Fewcott Road, Fritwell

Job Number: J323847	Date: 30 September 2019	Client: CALA Homes (Chiltern) Ltd
Prepared By: MF	Approved By: BF	Ref: 19/00616/OUT

Site Access Appraisal

drawing title	
Indicative Access Scheme	
Extent of Highway Boundary	
Visibility Splay (MfS - 30mph)	
ON193365	
ON141263

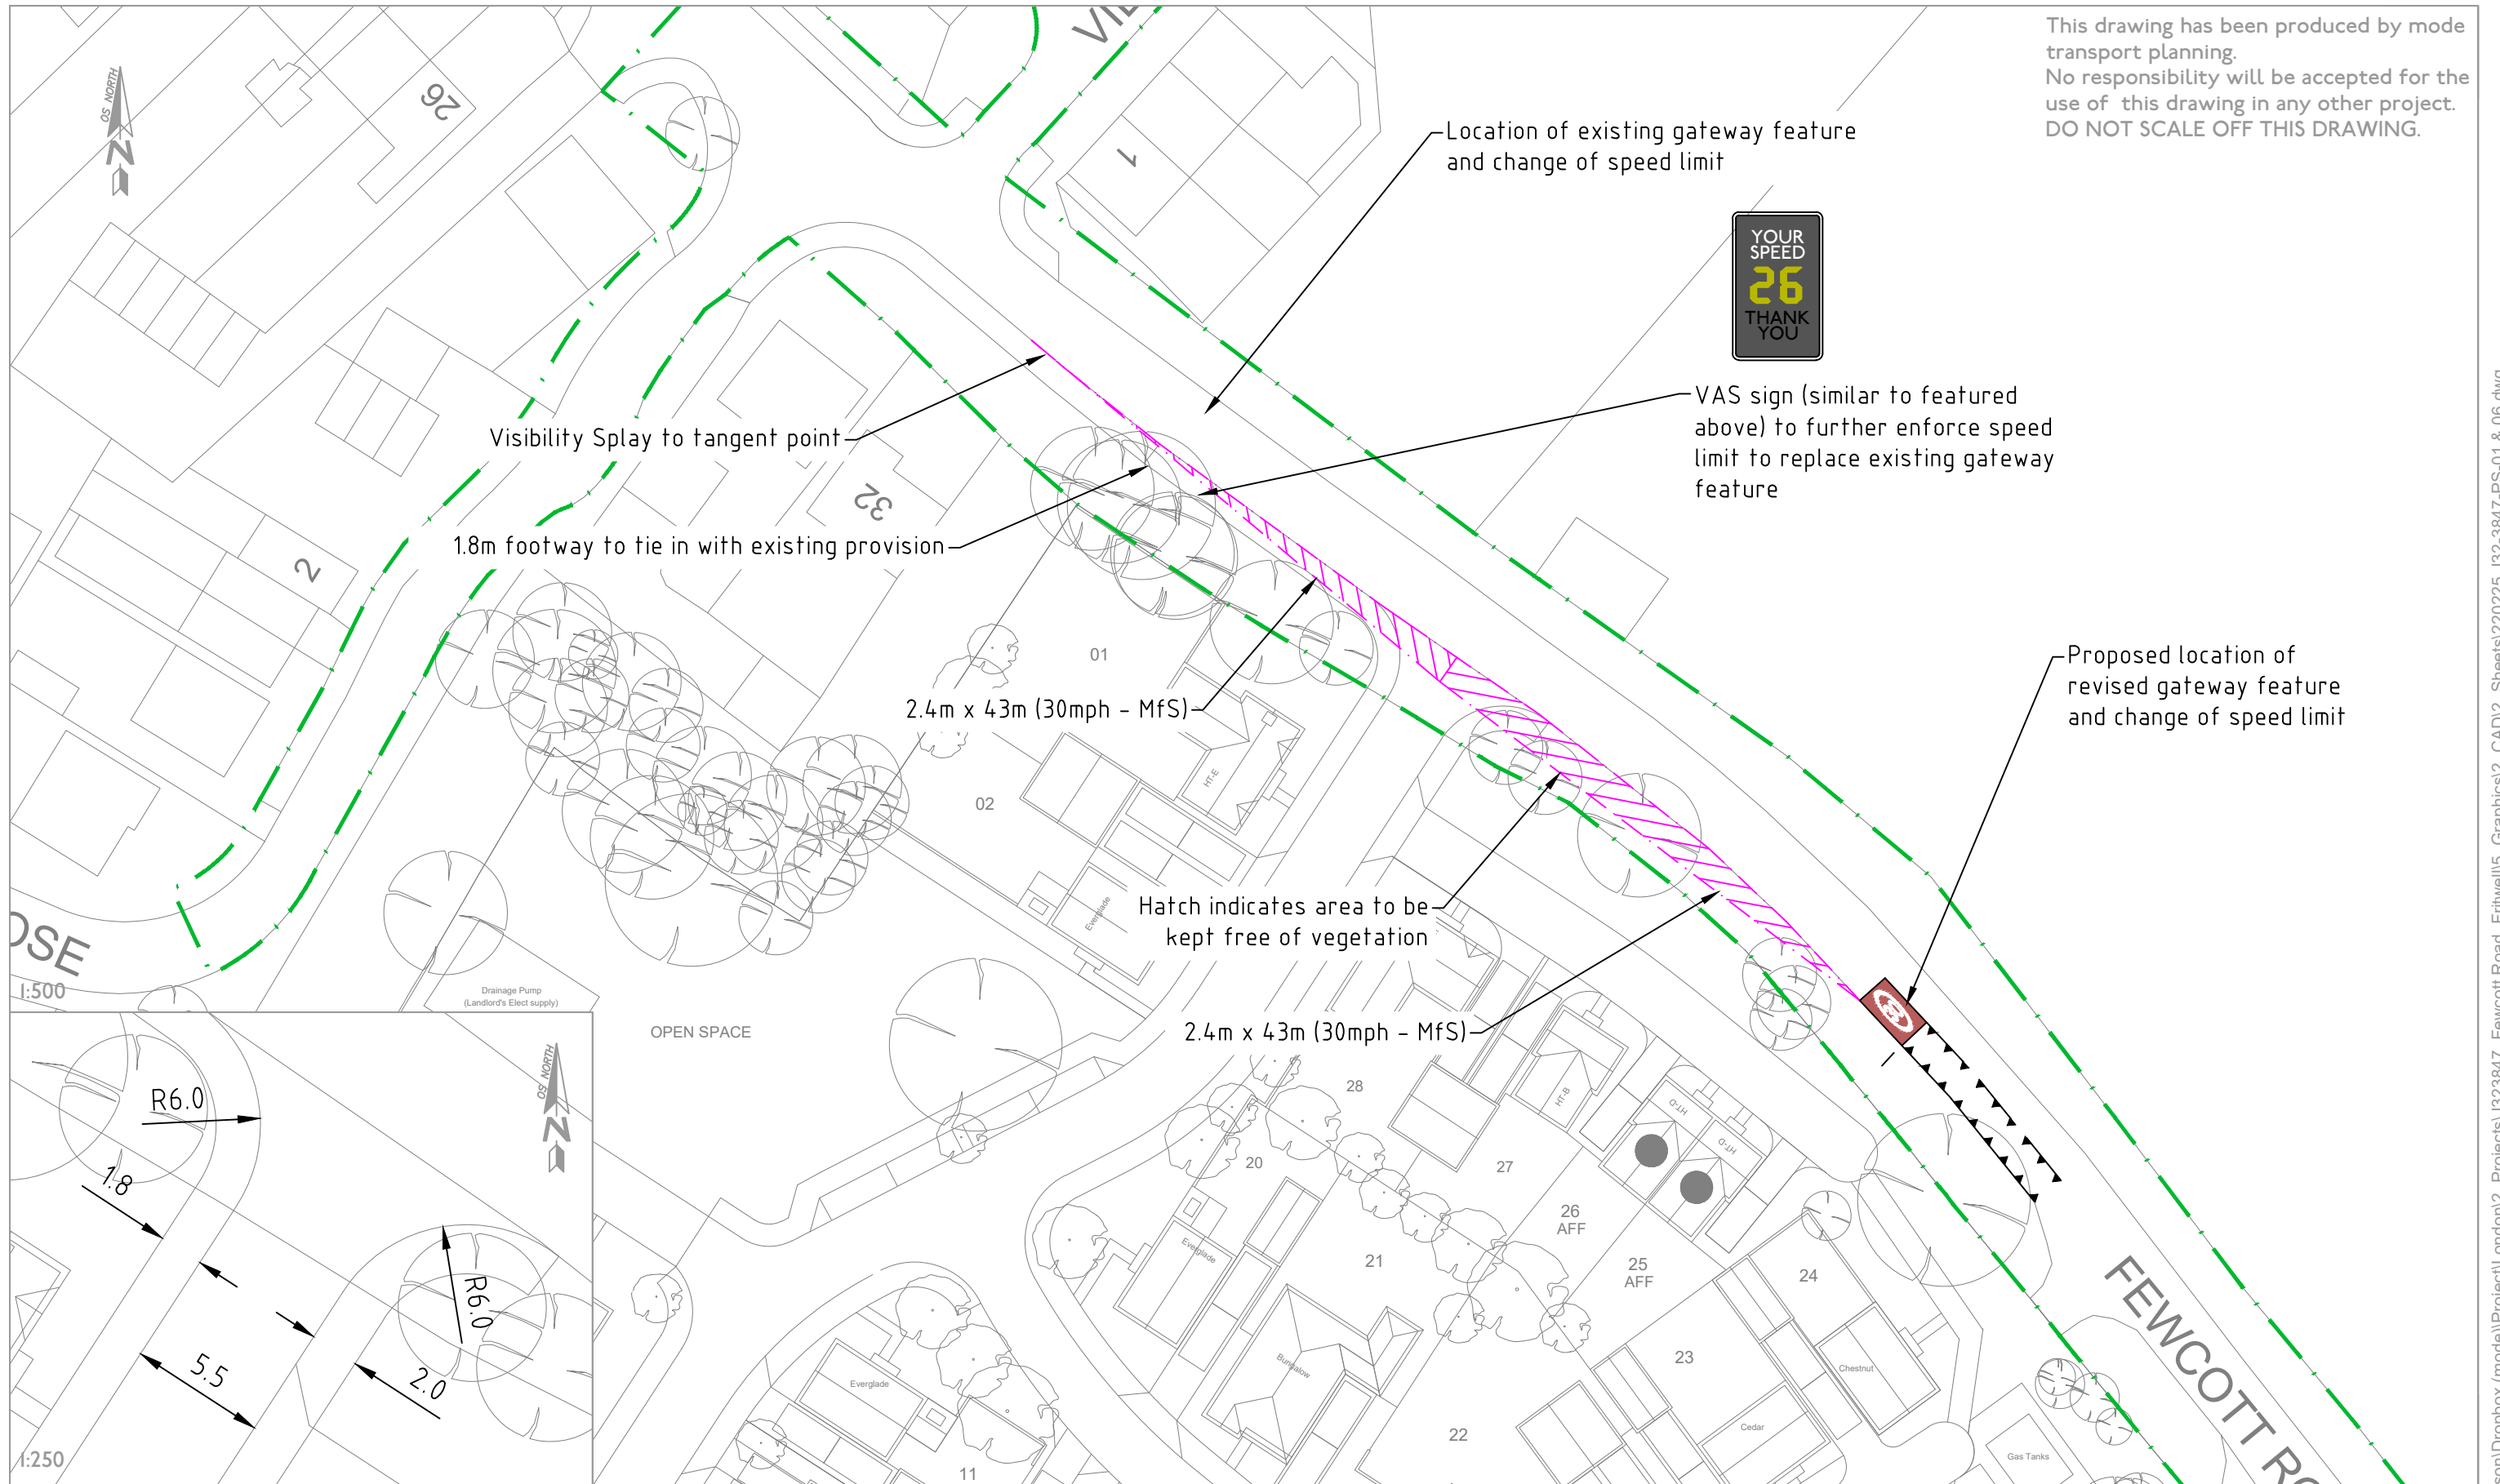
- 1.3 A summary of the OCC comments is provided below, with a full copy of the comments appended to this note as **Appendix B**:
 - Achievability of the visibility splays at the proposed site access relative to the posted speed limit;

- 3.3 The access strategy includes:
 - Providing a 5.5m carriageway width for the access to the site, with a 1.8m footway (both sides of the carriageway);

- Provide 6m entry radii at the site access; and,
 - To extend the footway from the site along Fewcott Road to connect with the existing footway provision within Fritwell, providing a 1.8m width pedestrian link for the development proposals.

- 3.4 To reinforce lower vehicle speeds past the proposed site access, the site access proposals seek to relocate the existing speed gate feature on Fewcott Road to a point approximately 30 metres to the south of the proposed site access. This would be provided in conjunction with "dragons teeth" road markings which will increase the visibility of both the change in speed limit and make drivers aware of the approaching junction. A Traffic Regulation Order (TRO) will also be required to provide the legal mechanism for the enforcement of the change in speed limit at its newly proposed position.

- 4.1 The visibility splay requirements for the proposed site access have been considered based upon both, 30mph speed limit which we are extending as per the proposals to relocate the village gateway feature and in line with the recorded vehicle speeds as described in **Section 2** of this note to provide a robust assessment
- 4.2 Horizontal visibility splays, in line with the relocation of the gateway feature and 30mph speed limit, have been based on the standards within MfS, which require a visibility splay of 43m in both directions to be achieved from a setback distance of 2.4 metres.
- 4.3 MfS standard visibility splay assessments are shown to be achievable in **Drawing J32-3847-PS-001 (Rev F)**. The splays can be delivered in either land in the control of the applicant or within the adopted highway boundary.

drawing title
 **Swept Path Analysis**

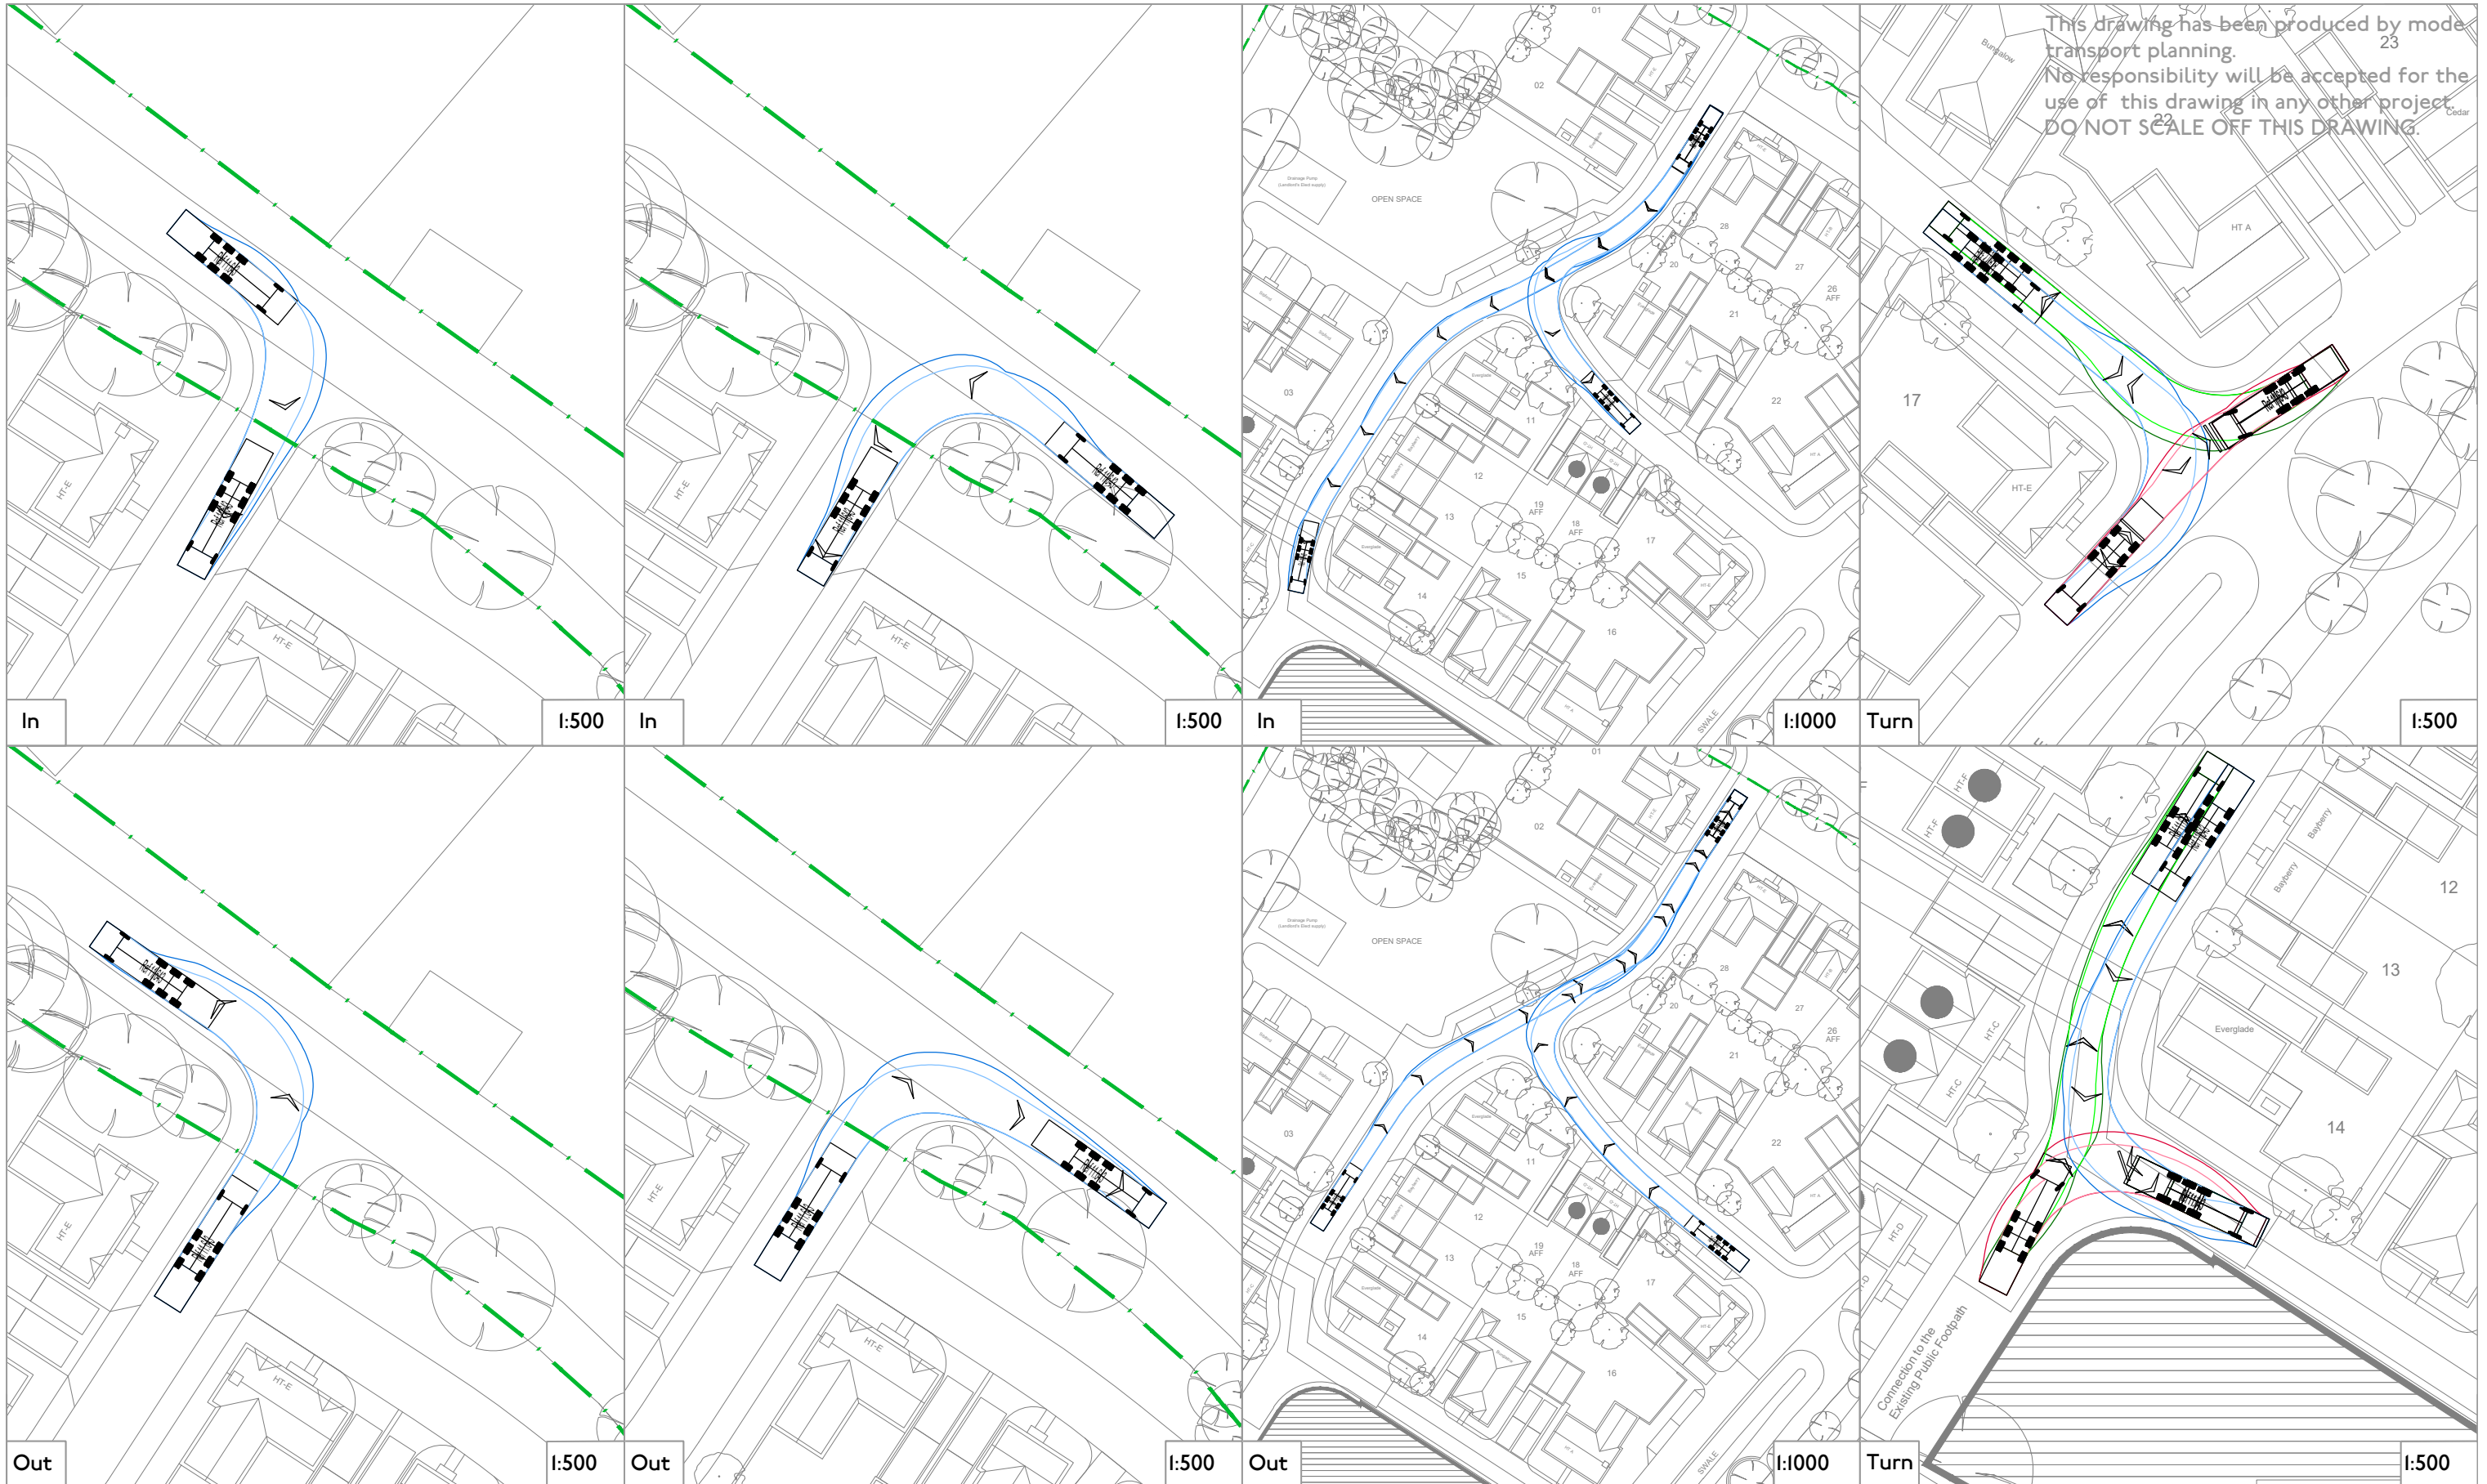
- Confirmation of on-site carriageway widths and refuse vehicle tracking;
 - Proposed parking numbers in line with OCC parking standards; and,
 - Deliverability of the proposed footway on Fewcott Road, of minimum 1.5m width, linking with existing footway provision.

- 5.2 Nonetheless, and in accordance with OCC guidance, a swept path analysis has been undertaken using an OCC standard refuse truck (11.643 metres in length) to ensure that it can access/egress the site. The refuse truck represents the largest vehicle that would be expected access to the site (including emergency vehicles).

- 5.3 **Drawing J32-3847-PS-006 (Rev B)** demonstrates that the design vehicle can access and egress the site but would be required to use the whole width of the carriageway. Given that refuse collection is infrequent, typically carried out outside of peak times, traffic volumes on this section of carriageway have been demonstrated to be low in the submitted Transport Statement and the access and internal road layout have been designed in line with OCC guidance, this is considered acceptable.
